Application no: H18/0156/09

Description: Proposed new workshop and alterations to
vehicular access

Location: Hospital Workshop
Hospital Road
Wingland

Amendment: Increase width of access by 2 metres

AMENDED PLAN
Ref. A1

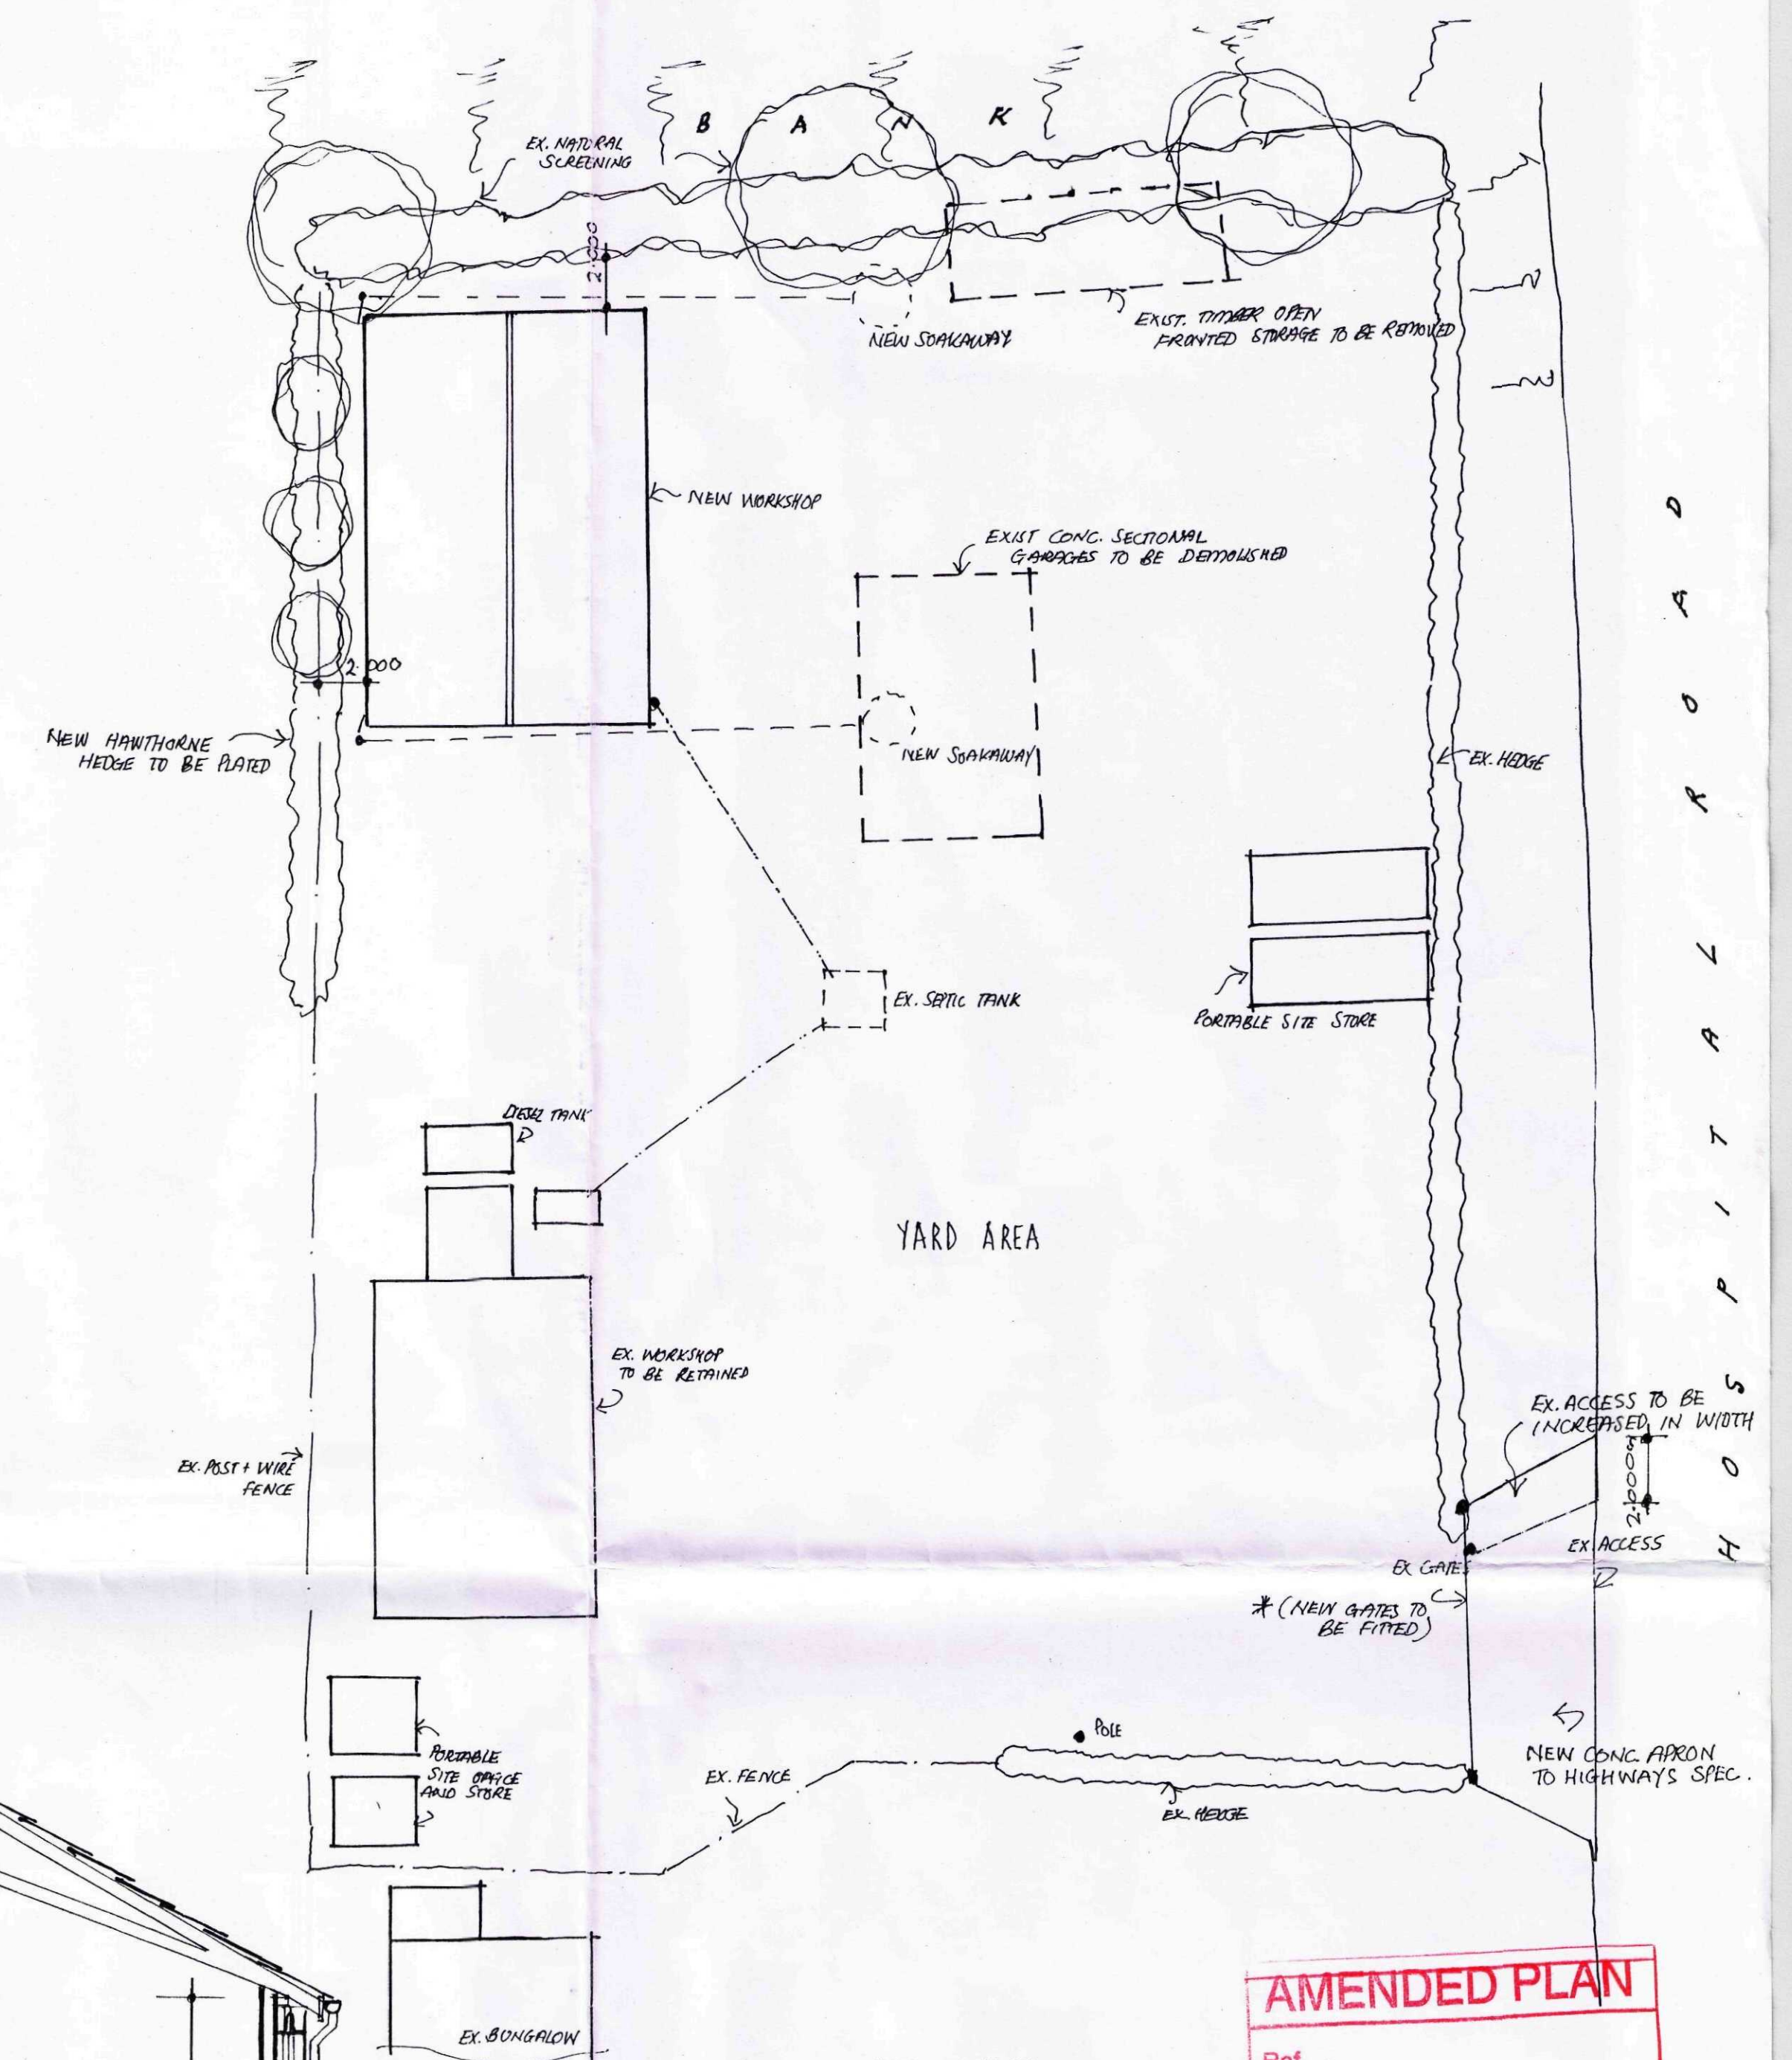
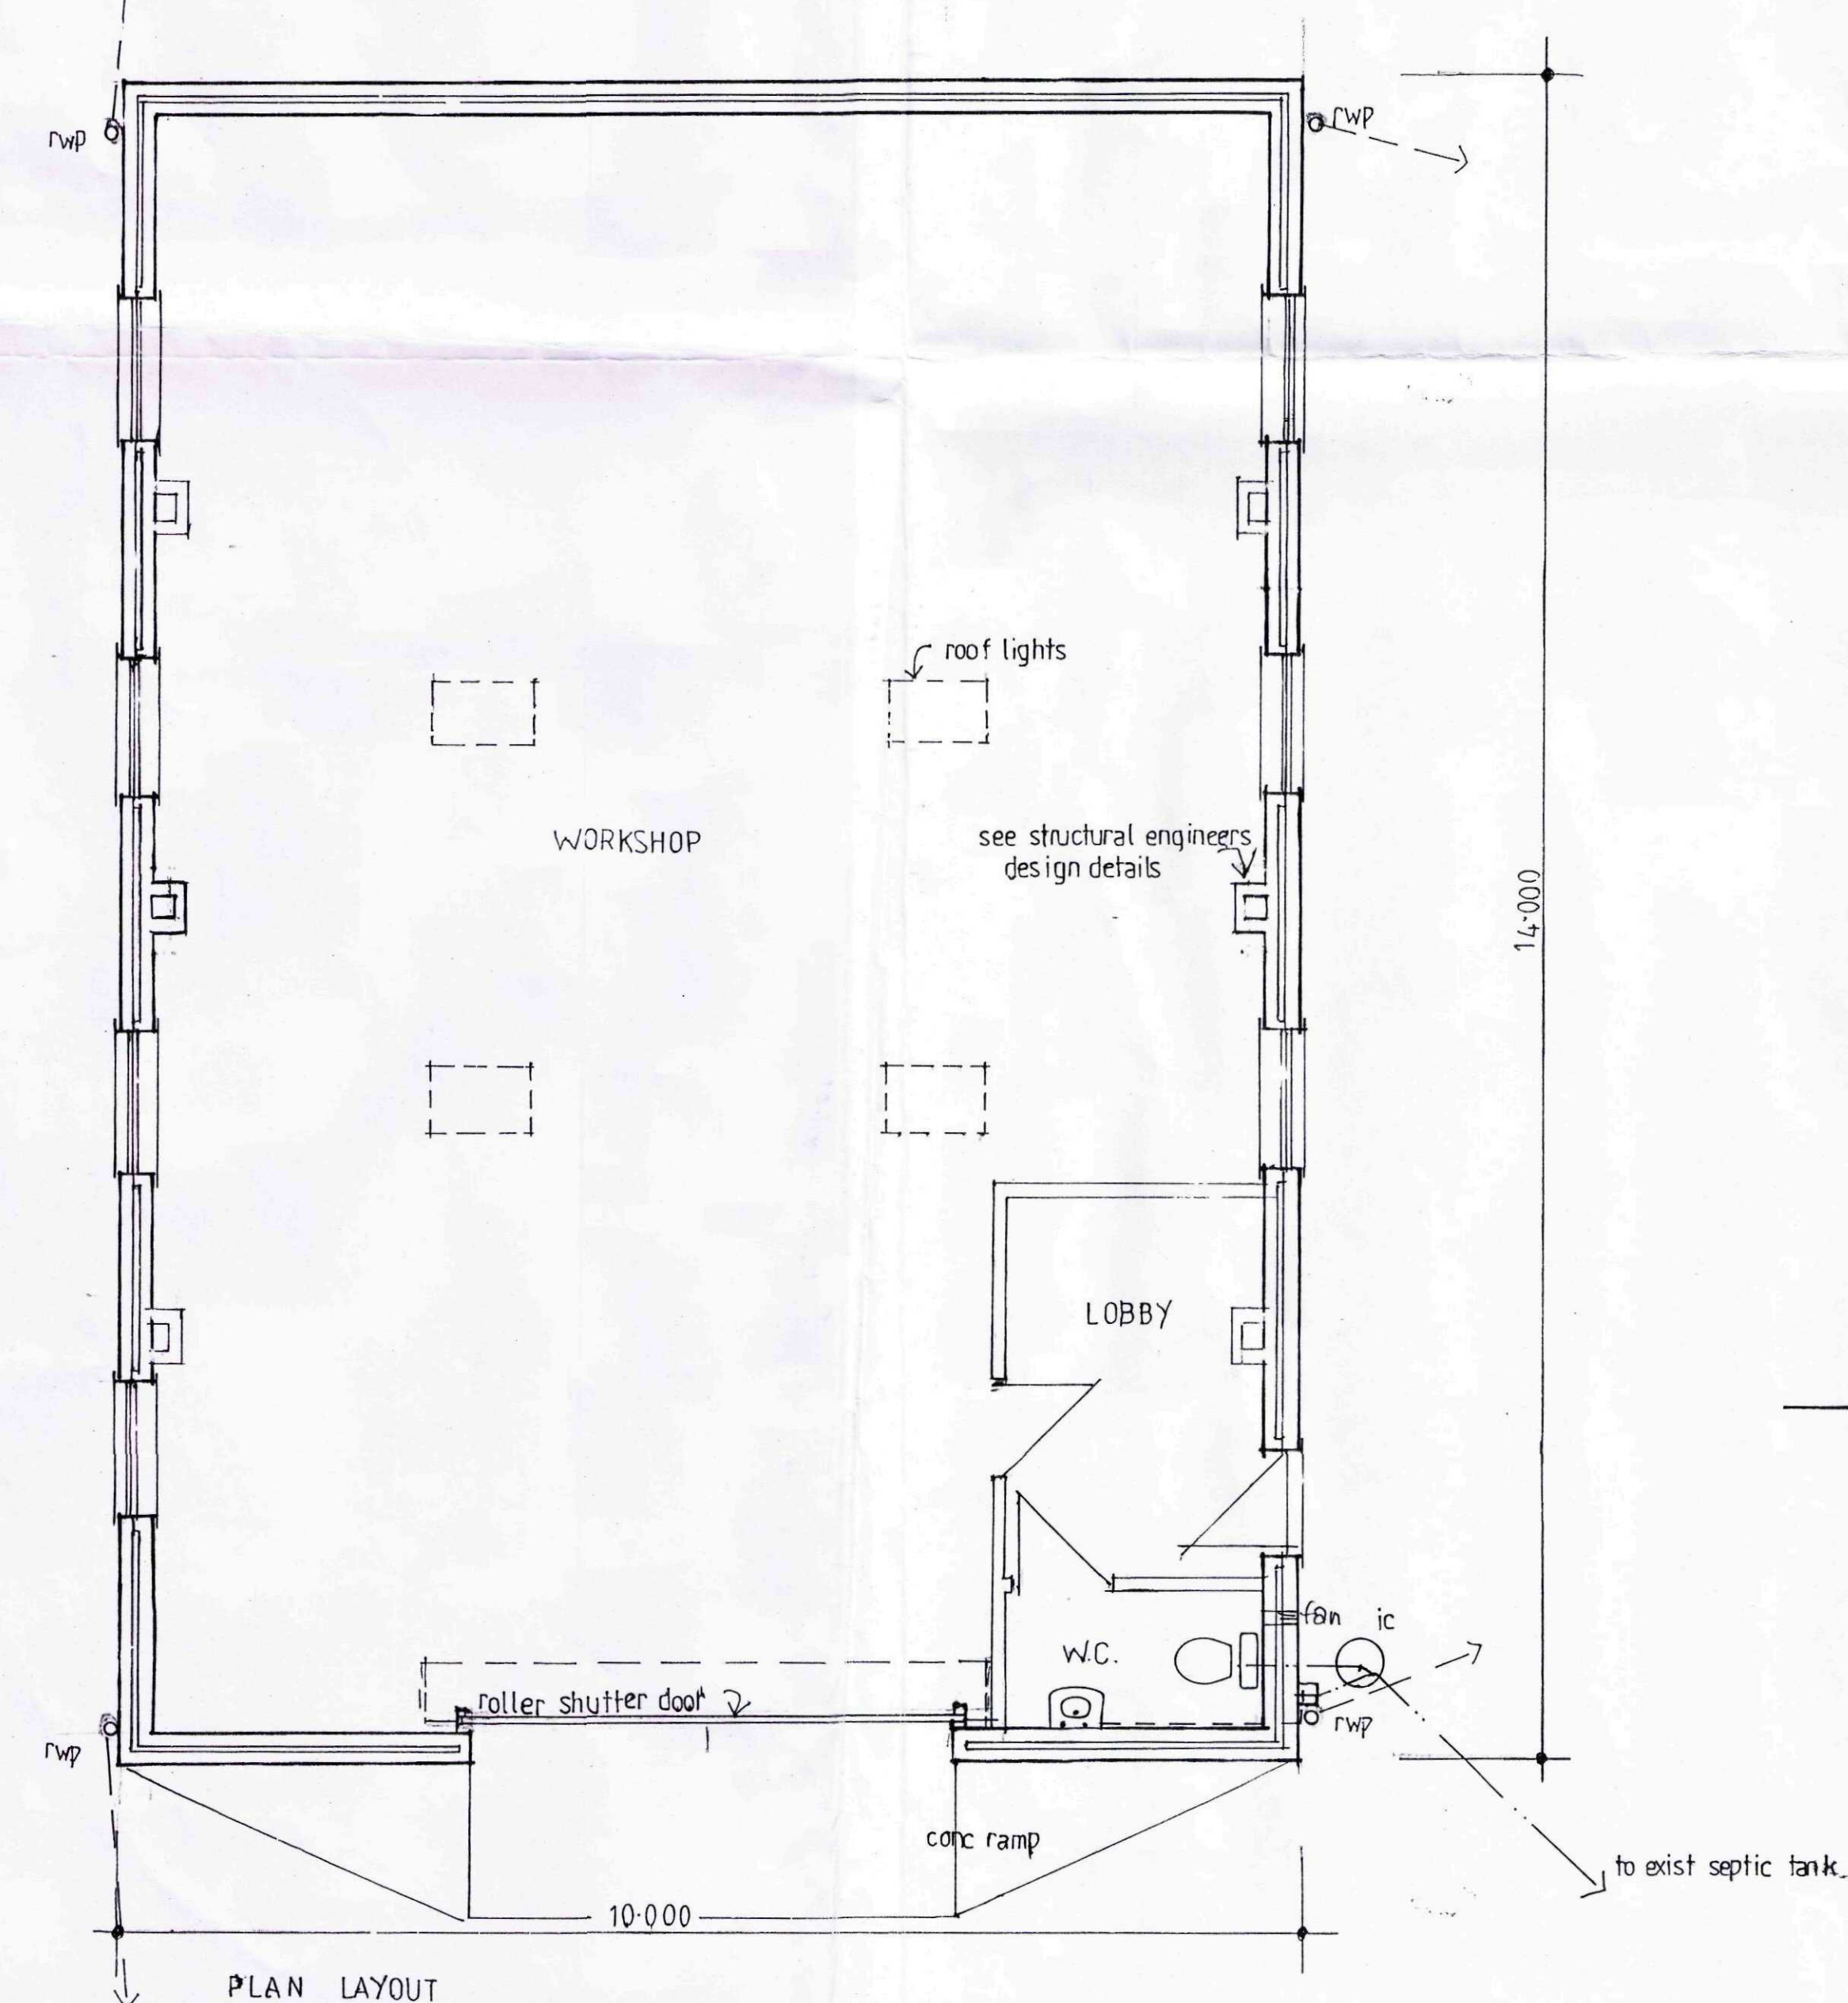
Description Increase width of access by 2m.
